Name of Application:- Cherrybrook Railway Station Precinct EIS 2 Submission

Application Number:- SSI-5414

Figure 6.12 Cherrybrook Station - Indicative vehicle and pedestrian movements

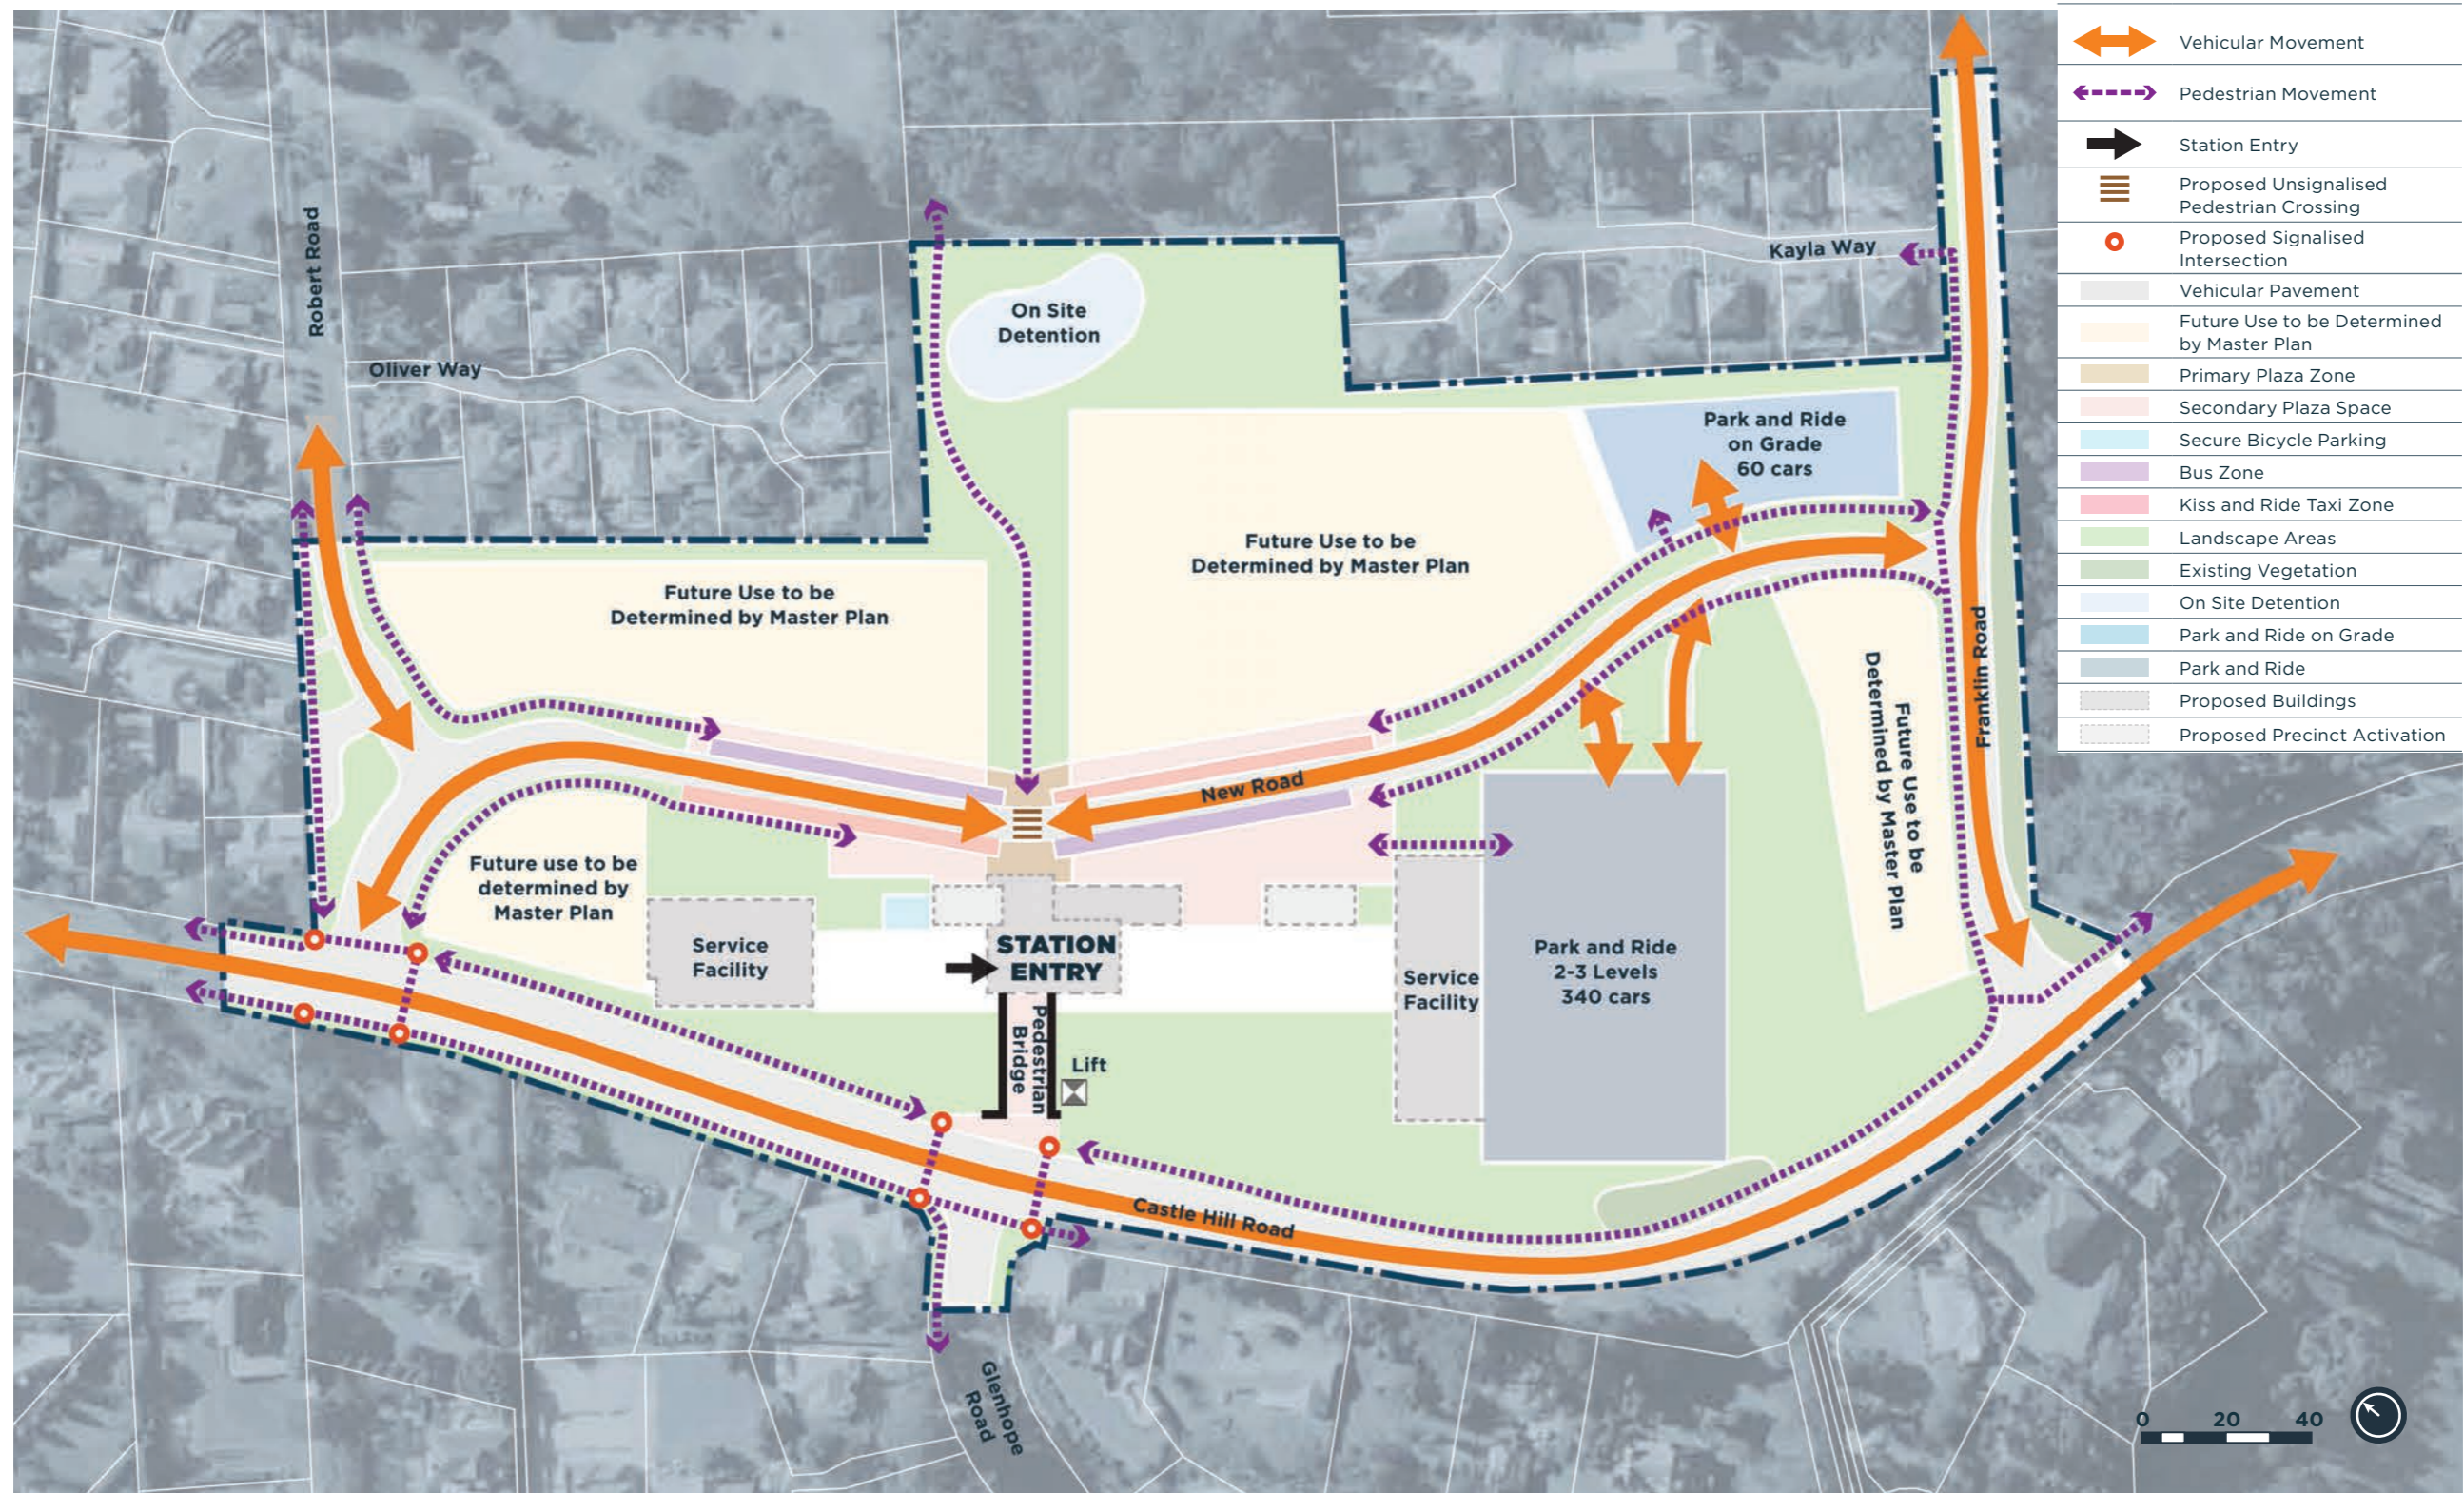
EIS 2 suggests that plans are in place to convert Robert Road, Cherrybrook, into a bus route and main access road for the Cherrybrook station. We vehemently object to the proposal on the following grounds:

Robert Road is a narrow tree-lined street which is 7 metres wide and is not built to act as a main road or bus corridor, even with the addition of No Parking zones.

To date, residents have been given no credible reason why Robert Road is suggested as a bus route, especially when there are existing roads within one block in either direction, which provide a low cost and low impact alternative (i.e. Castle Hill Road, County Drive and Franklin Road) and which:

- a) Are built to handle large volumes of traffic unlike Robert Road;
- b) Are built to handle large vehicles unlike Robert Road;
- c) Are currently under-utilised unlike Robert Road; and
- d) Will not present the traffic hazards and safety issues that will arise from pushing bus and commuter traffic onto a narrow suburban street such as Robert Road.
